Jean Fraser - 133 York St

**From:** Erin Foley <efoley19@aol.com>  
**To:** Jean Fraser <JF@portlandmaine.gov>  
**Date:** 10/22/2013 4:47 PM  
**Subject:** 133 York St

As far as the project at 133 York Street I would like to bring up the following concerns:

FRONT VIEW

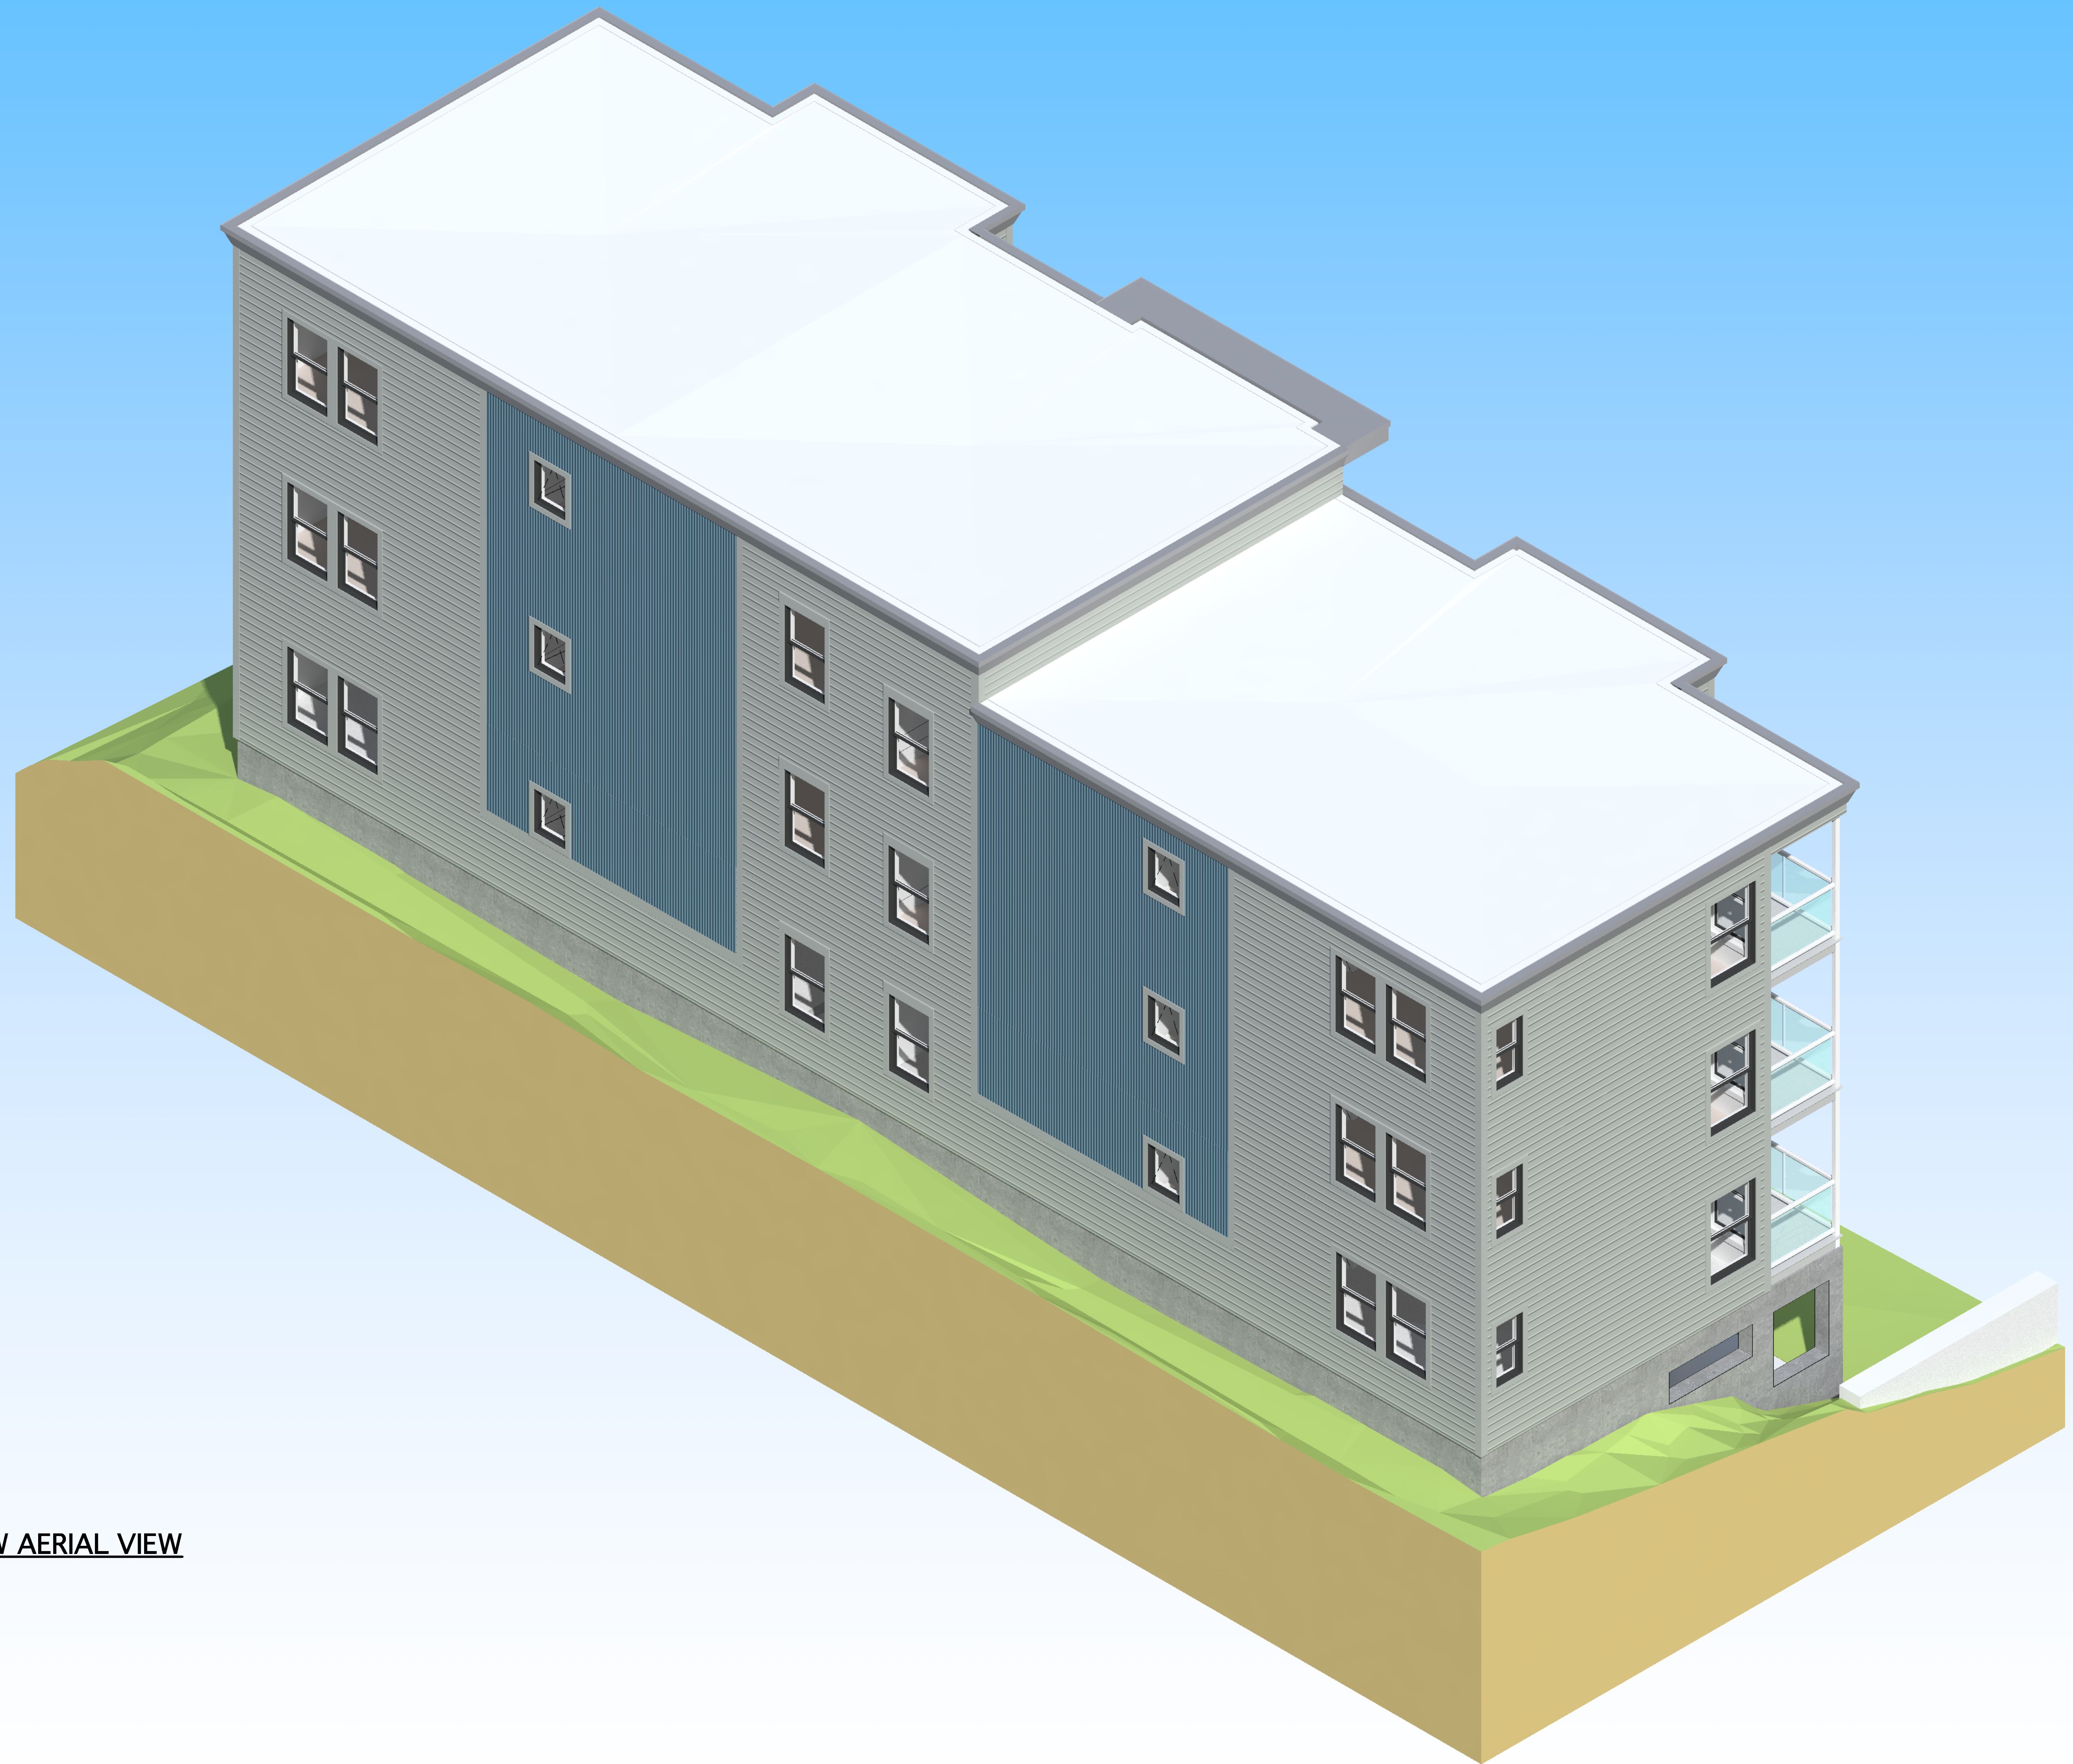
2. This building does not fit in with the feel of the neighborhood. According to R-6 Design principles and Standards " A building design shall contribute to and be compatible with the predominant character-defining architectural features of the neighborhood" "they have a public responsibility to add to and enhance the neighborhoods in which their projects are built." This building is less than 100 feet from the historic district and within the West End. Most homes within the neighborhood maintain historic qualities or make an effort to blend in with the feel of the neighborhood. See image 2 .

Is there a reason for the teal stripe, could this possibly be a different shade of gray instead of teal. There are no other properties in the neighborhood that include teal as part of their color choices.

Also, is there architectural significance to the height of the building being 2 different heights?

The height of this building will impact water views for 3 units at McCormick Place. I recently had my home reappraised and the water view is taken into account when determining the value of my home.
